**KIRKLEES METROPOLITAN COUNCIL
INVESTMENT & REGENERATION SERVICE**

Reference No: 2018/62/90696/W

Site Address: 34, Meadow Lane, Slaithwaite, Huddersfield, HD7
5EX

Description: Erection of rear extension and conversion of garage to
living space and formation of additional parking
spaces

Proposed Elevations

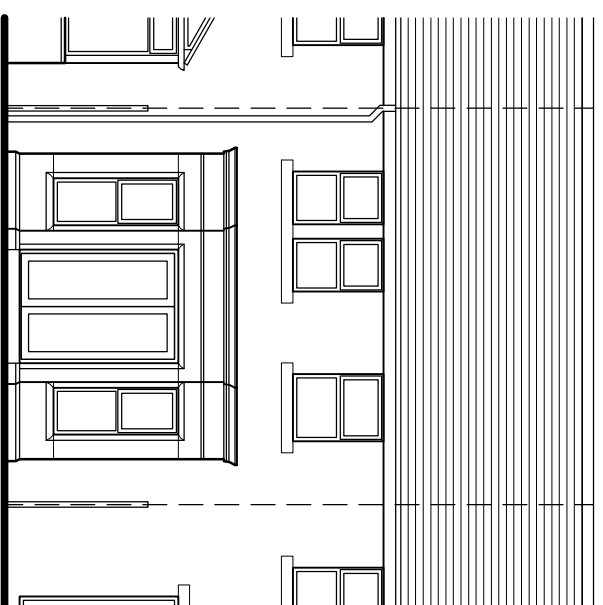
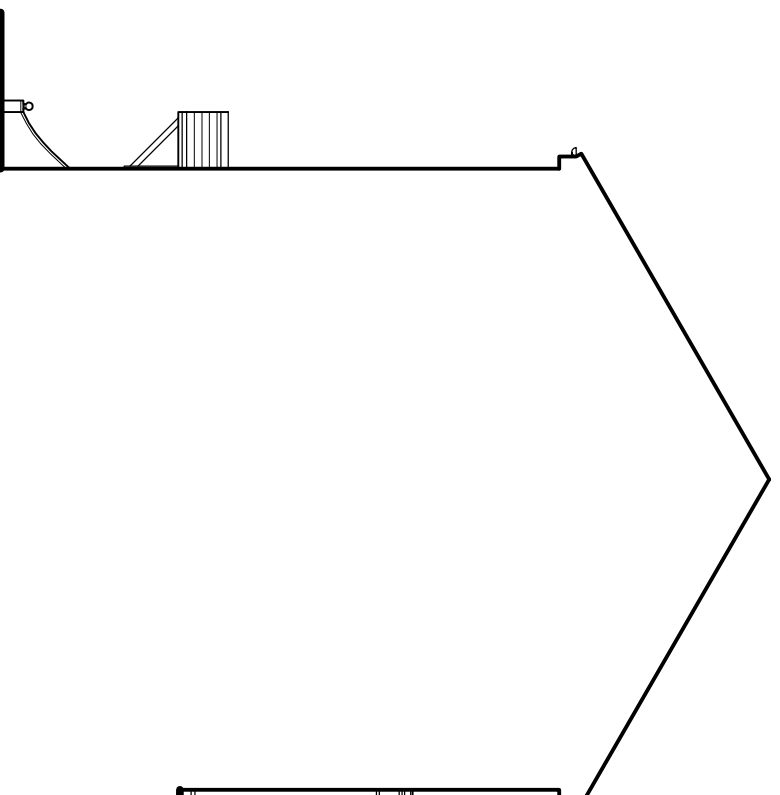
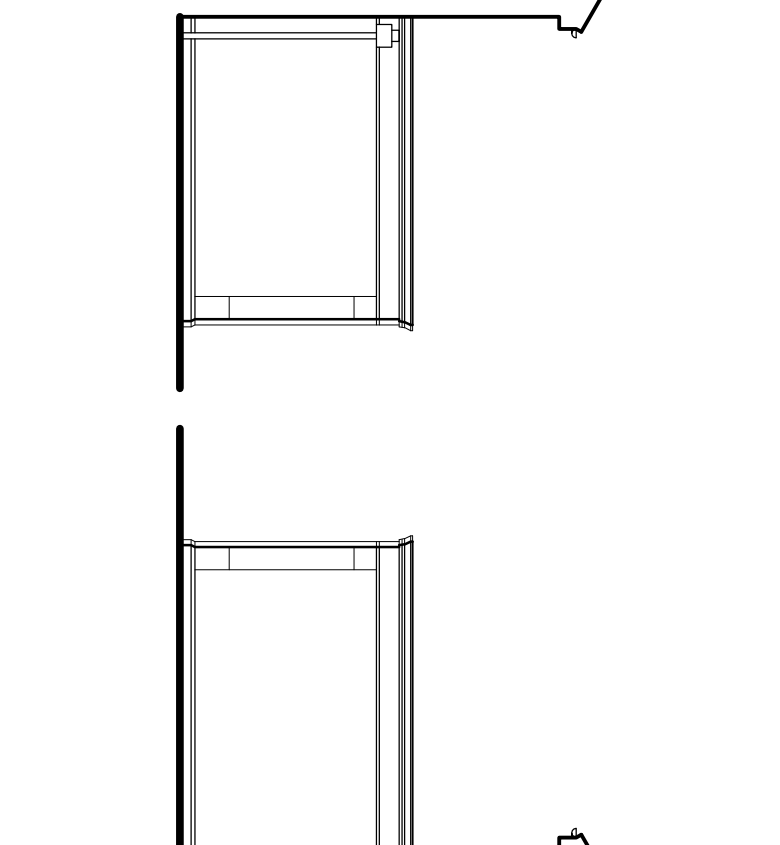
Negotiations were held between the agent and planning officer regarding the inclusion of a bay window. Planning officers believed that the inclusion of the bay window served to harm the visual amenity of the dwelling and overall streetscene. As such the bay window was omitted from the plans.

The application would introduce a porch on the south facing elevation which would adorn the main access to the dwelling. Typical of a porch, the proposed would be small in scale, projecting by approximately 0.78m and would serve to offer the principal elevation of the dwelling an acceptable level of character. This element of the scheme is considered to be minor and is not believed to materially alter the appearance of the dwelling, retaining the established vernacular as the dominate element.

With regard to the proposed garage conversion, it is noted that the scheme would not result in an increase in the footprint of the garage. Rather the only material change would be the removal of the existing garage door, replaced by a bank of three windows. Such an alterations is again not anticipated to result in any harm to the visual amenity of the building. Conversely, the bank of three windows is considered to offer a level of continuity with the banks of windows above.

To the rear of the property it is proposed to construct a single storey extension, designed with a flat roof, hosting a roof lantern and constructed from stone and uPVC windows. The extension would have a total ridge height of approximately 3m, project from the rear elevation (north) approximately 4m and have a total width of 4m.

With regard to the rear extension, this has been designed such that it would be set in from the boundaries with no.32 and no.36. As such the proposal would not serve to bring the application dwelling any closer to neighbouring dwellings. Furthermore, as a single storey extension, designed with a flat roof and screened by substantial boundary treatment this aspect of the development is not anticipated to give rise to any undue overlooking or overbearing concerns. In any case the extension has been designed without any opening in the side elevations thereby removing the opportunity to overlook completely.

Negotiations were held between the planning officer and applicant regarding the proposed bay window. Such an addition was considered to harm the visual amenity of the considered dwelling and streetscene overall. Consequently, revised plans were submitted omitting the bay window and the application resolved.
